THE METHODIST CHURCH

BROAD STREET METHODIST CHURCH, SPALDING – SPALDING (17/15)

Reconfiguration of storage areas and refurbishment of toilet area (Project Ref. 53712)

27th May 2025

BROAD STREET METHODIST CHURCH
RECONFIGURATION of STORAGE and WCS
ELEVATIONS and CROSS SECTION

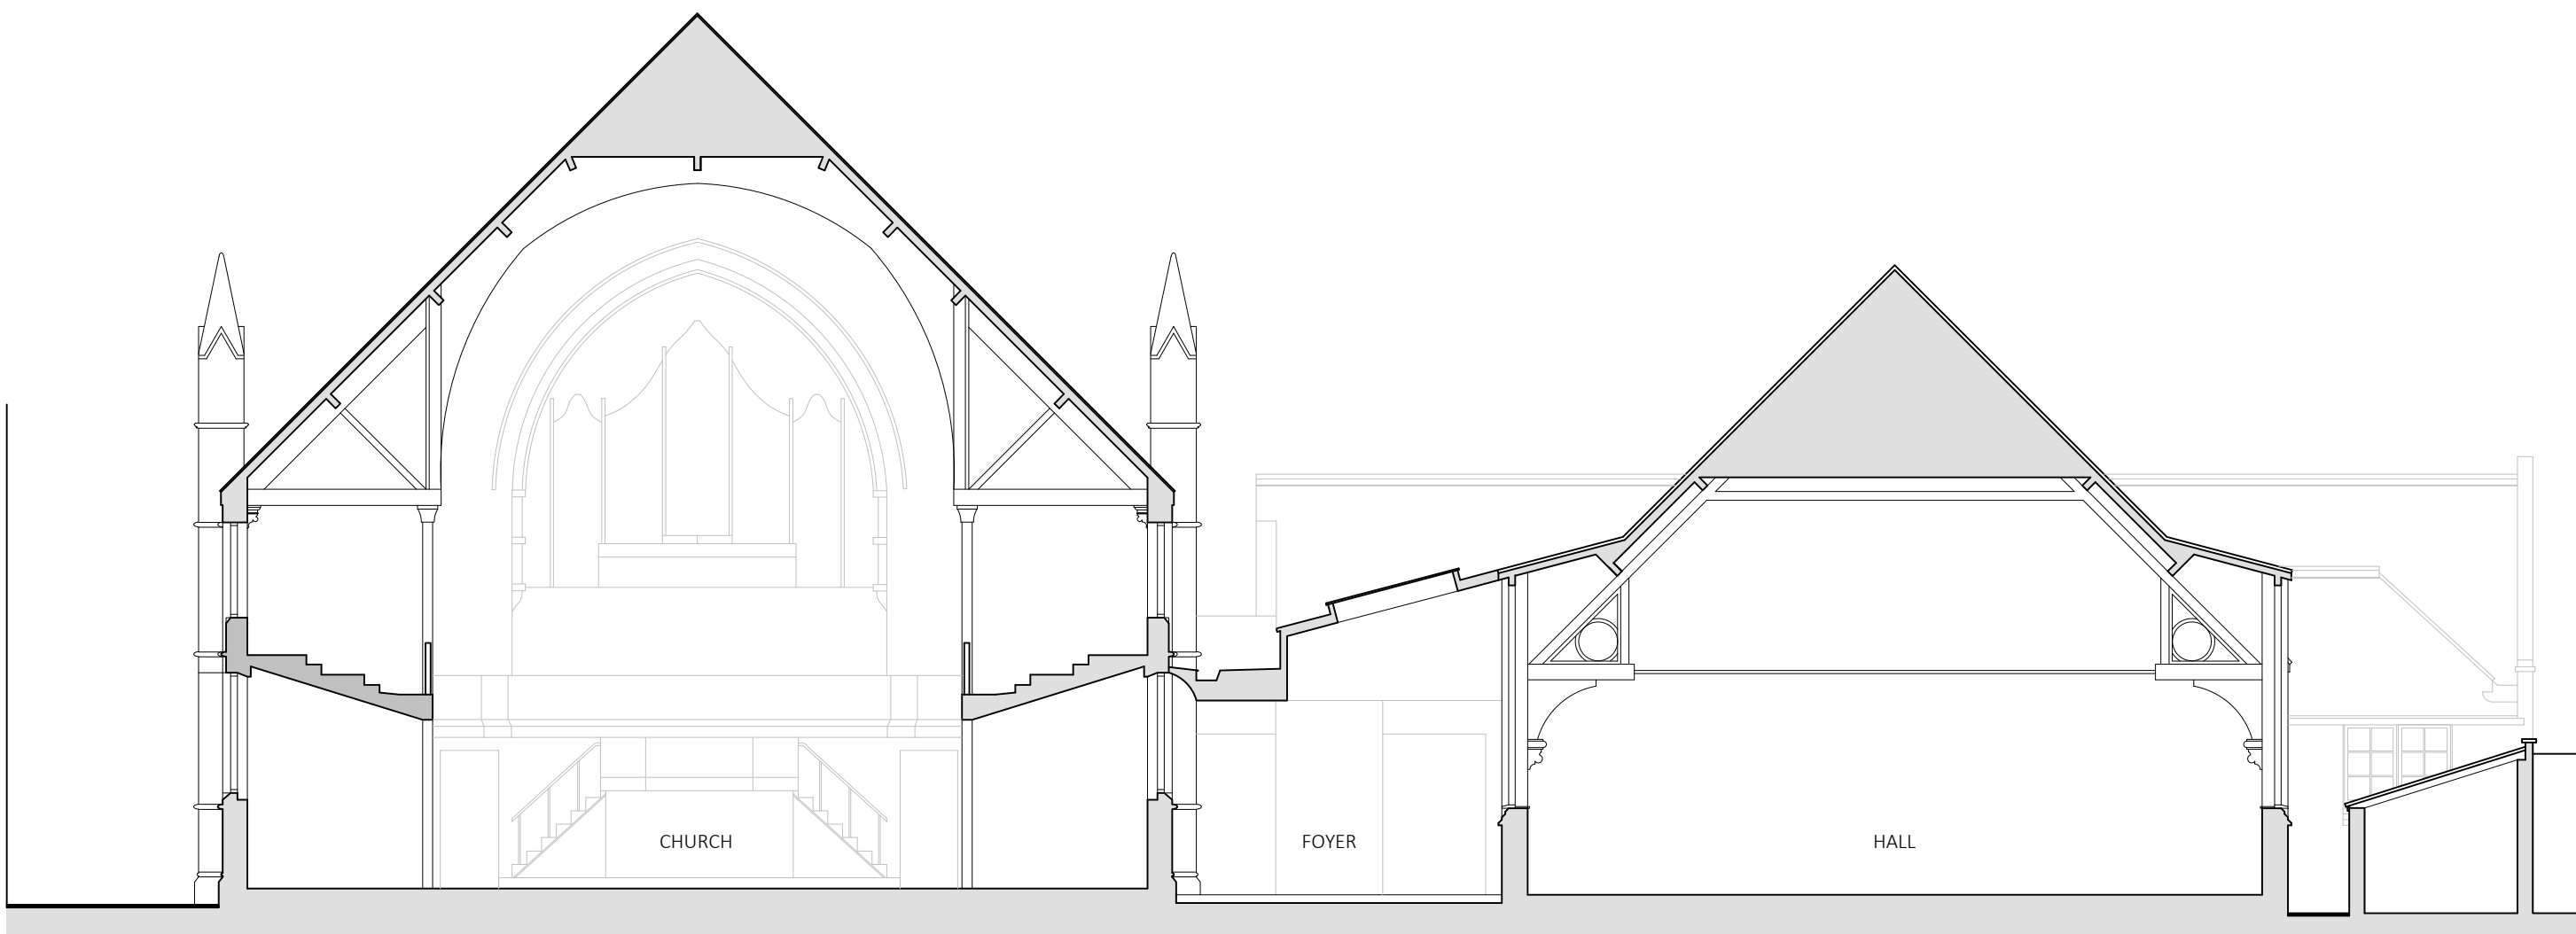
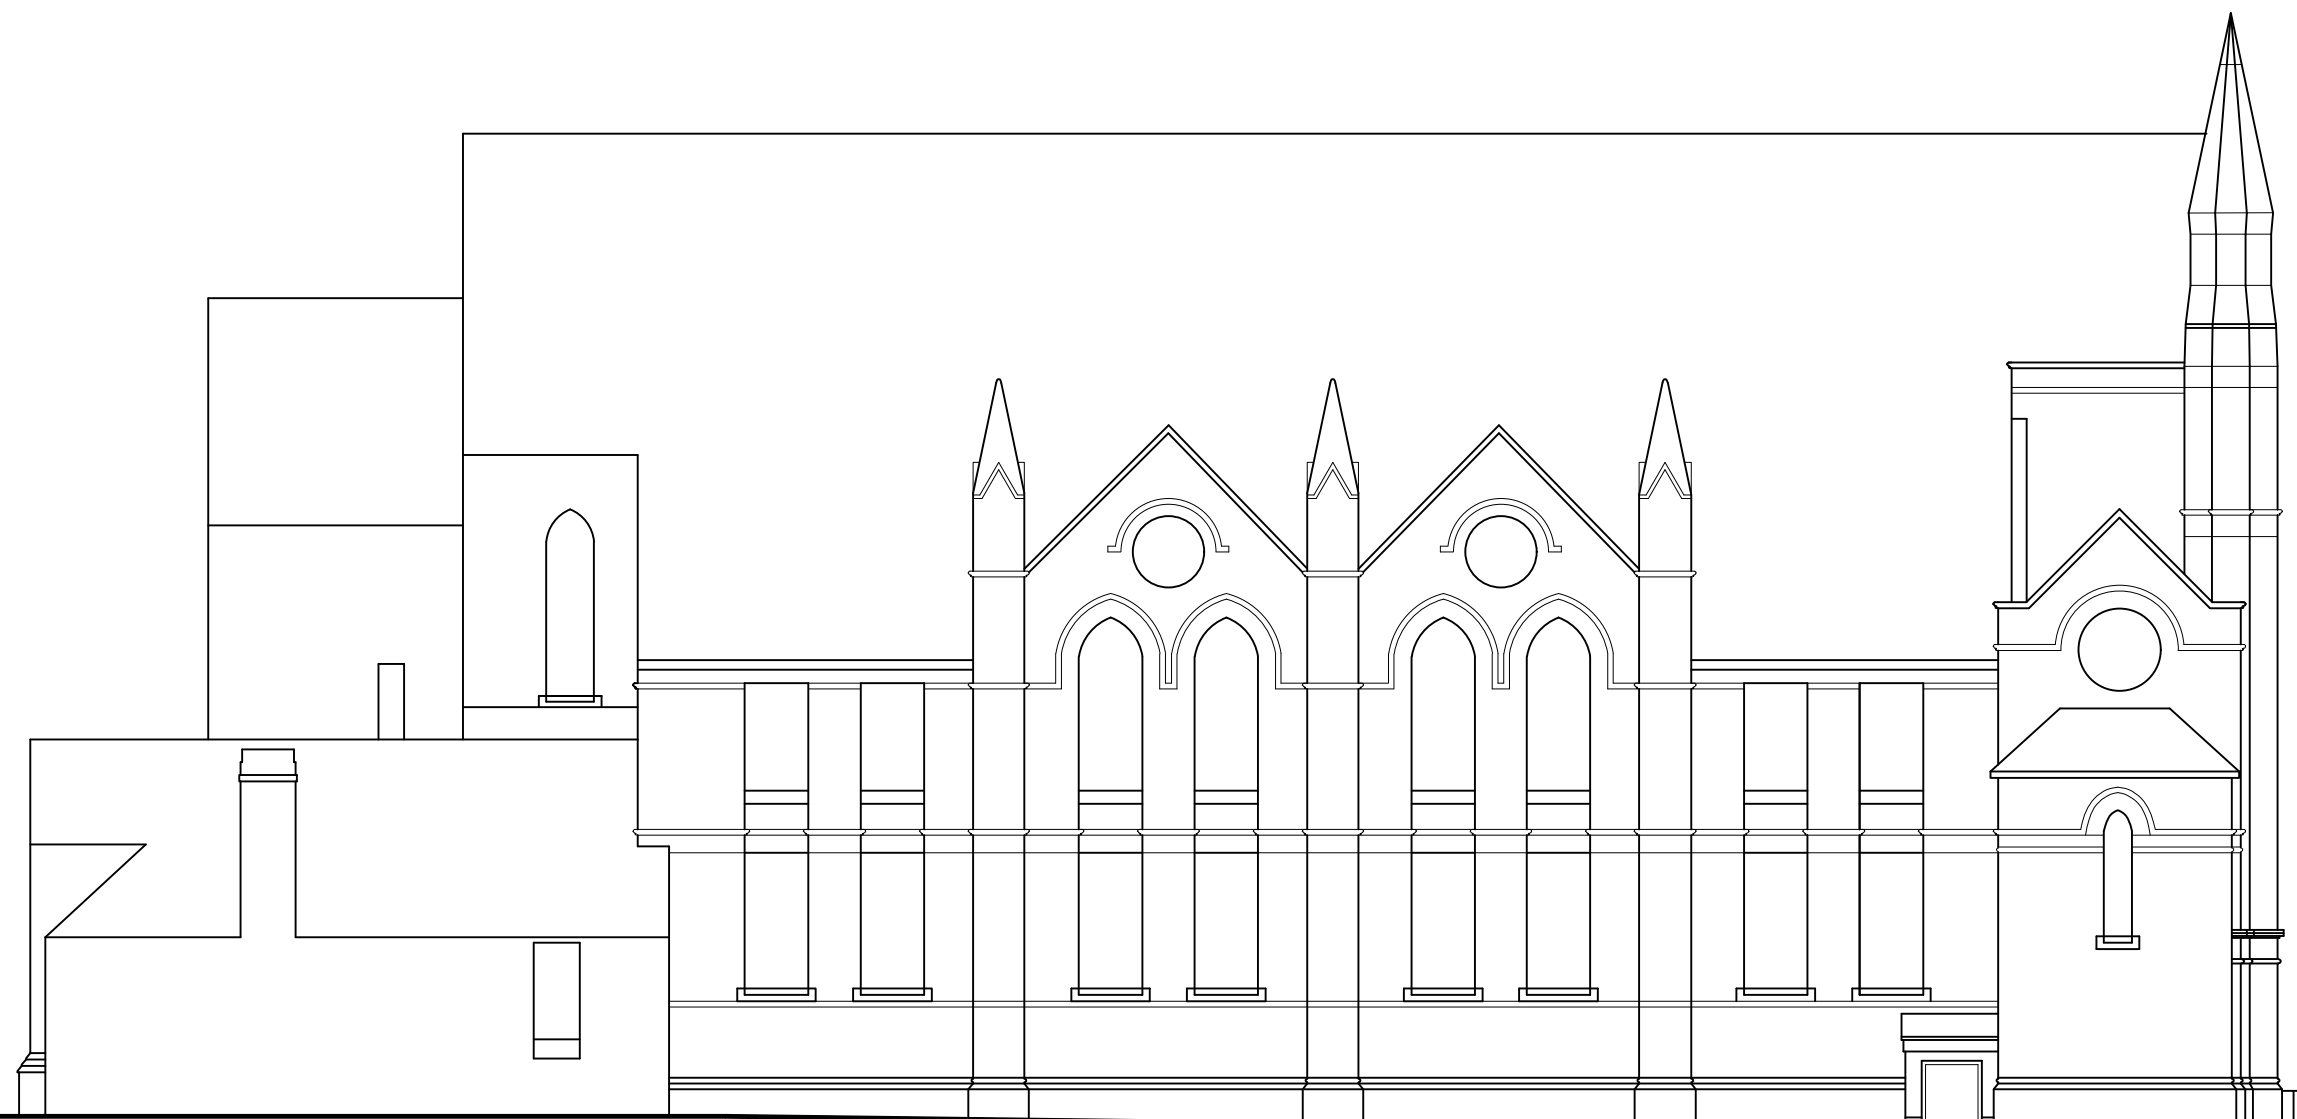
Historic England	Historic England raises concerns about the staircase demolition and the proposed extension due to insufficient information and justification. They seek assurance through a HIA, Elevations of the Proposed Extension and Statement of Need. The location of the staircase to be removed is unclear from the plans.
Historic Buildings & Places (formerly the AMS)	Raise no concerns.
The Georgian Group	No representation received.
The Victorian Society	Do not wish to comment.
Local Planning Authority (LPA)	No formal representation received.
Listed Building Advisory Committee (LBAC)	The LBAC wished to commend the church on their continual efforts to repair and improve this historic building. Members offered the following comments: a) Whether the recent decision in the Supreme Court on gender would lead the church to reconsider the W/C element of the proposal? Other members commented on how they felt the proposals would indeed reflect recent legislative decisions i.e. having ungendered designation or no gender designation is actually working with the decision that was recently made. b) Initial concerns had been satisfied by the Statement of Significance, which made it clear that the staircase has very little significance; the storage area extension will have minimal impact on how the right-hand side of the elevation will be seen and perceived from the street.

BROAD STREET METHODIST CHURCH
RECONFIGURATION of STORAGE and WCS
EXISTING STAIR

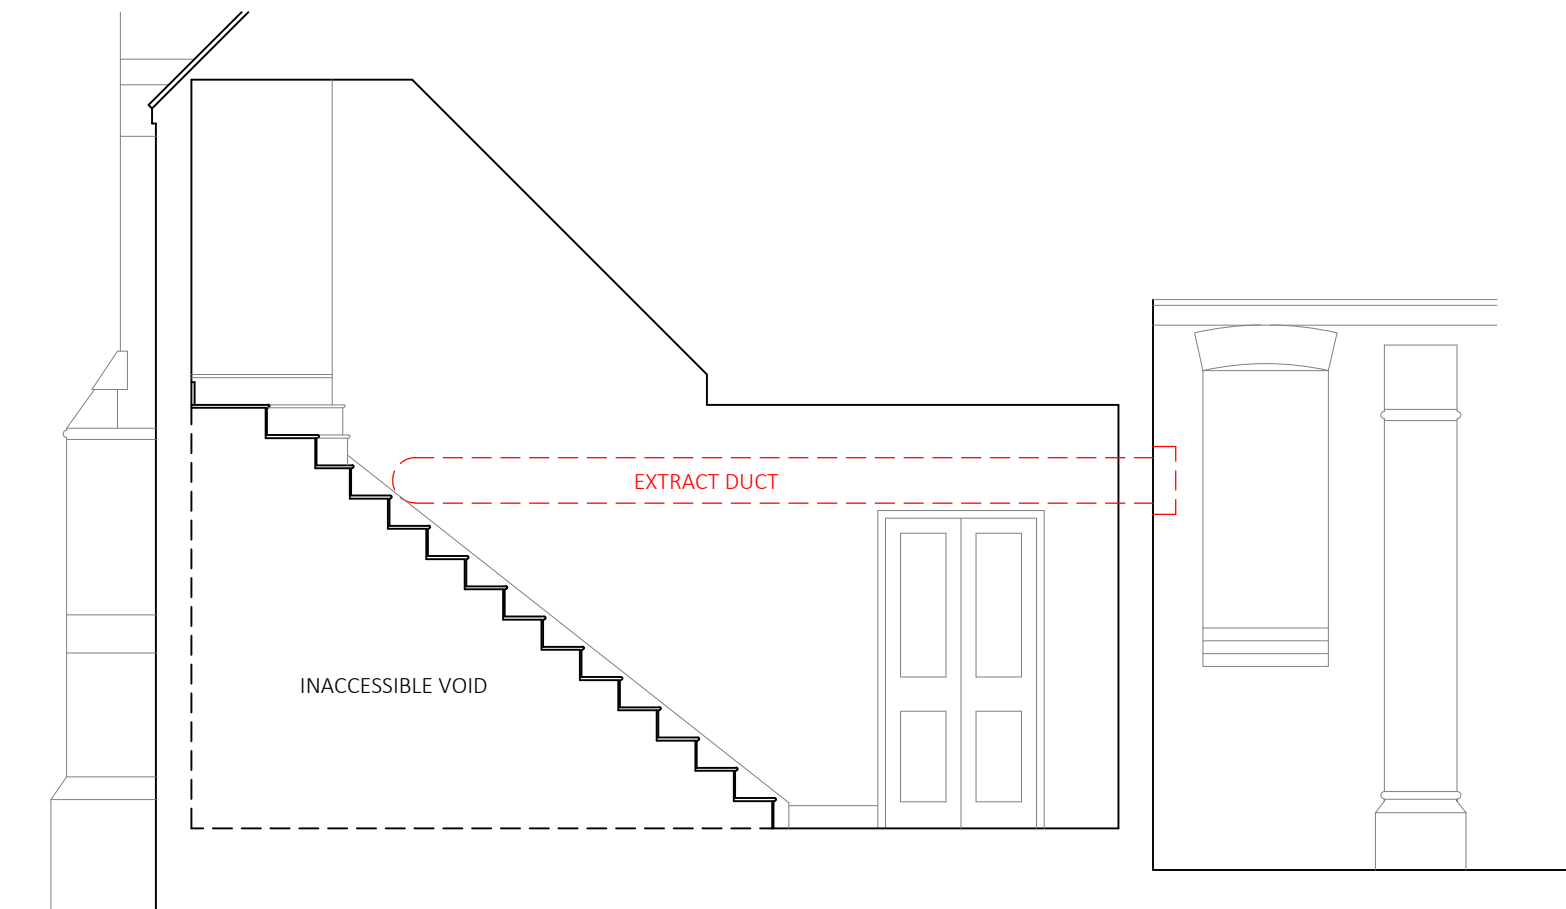
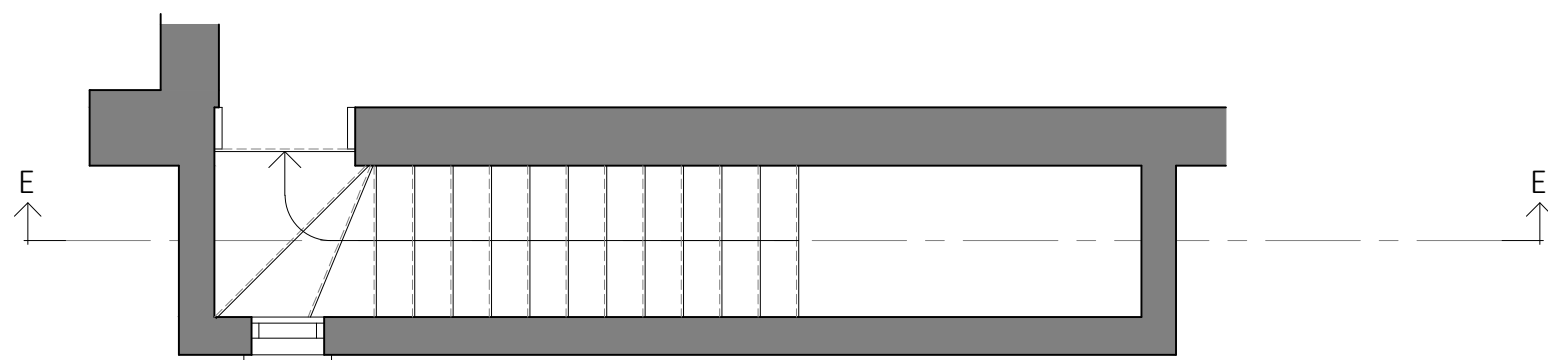
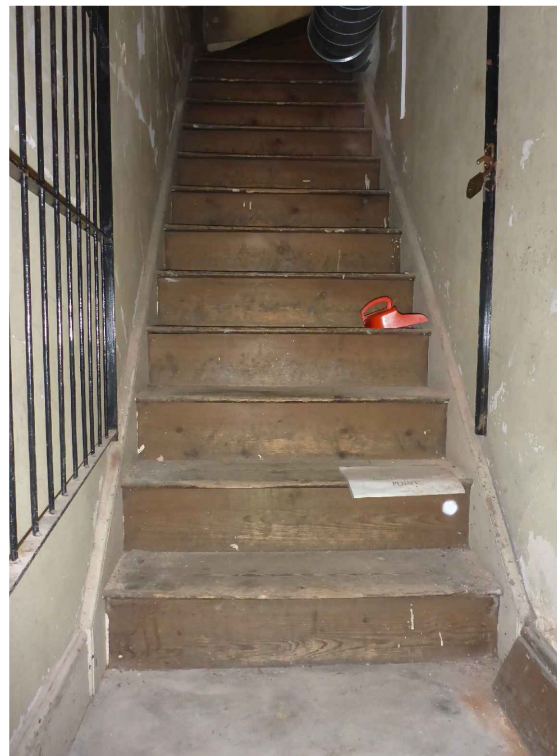
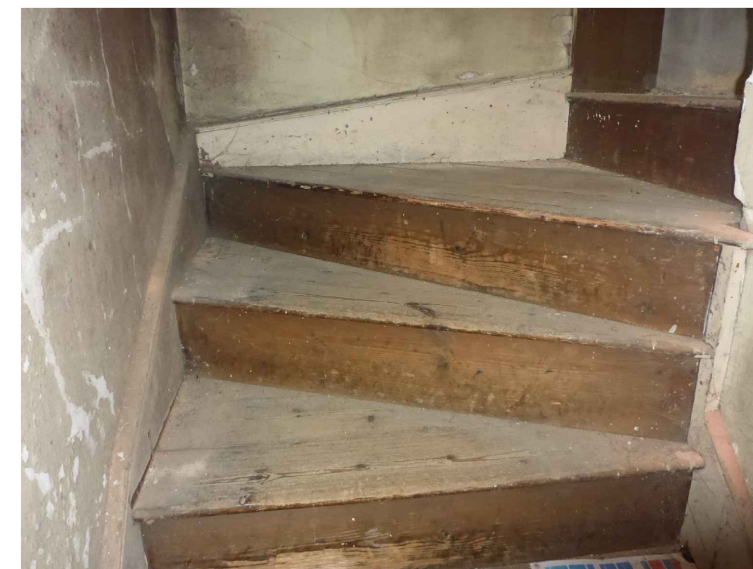
The new extension has been designed to minimise the impact on the character and appearance of the building and the details are considered to be acceptable. We should however, address the issues raised by Historic England regarding the lack of information and justification relating to the staircase; further information has been supplied by the professional advisor that clearly shows the staircase is of low significance. Elevations of the proposed extension clearly show that this will have minimal impact on how the right-hand side of the elevation will be seen and perceived from the street, as was pointed out by the LBAC. The Committee sought assurance from the church that they were not intending to make any alterations to the proposal following the recent decision in the Supreme Court concerning gender. No response has been received to this question, and therefore we presume that no changes are proposed.
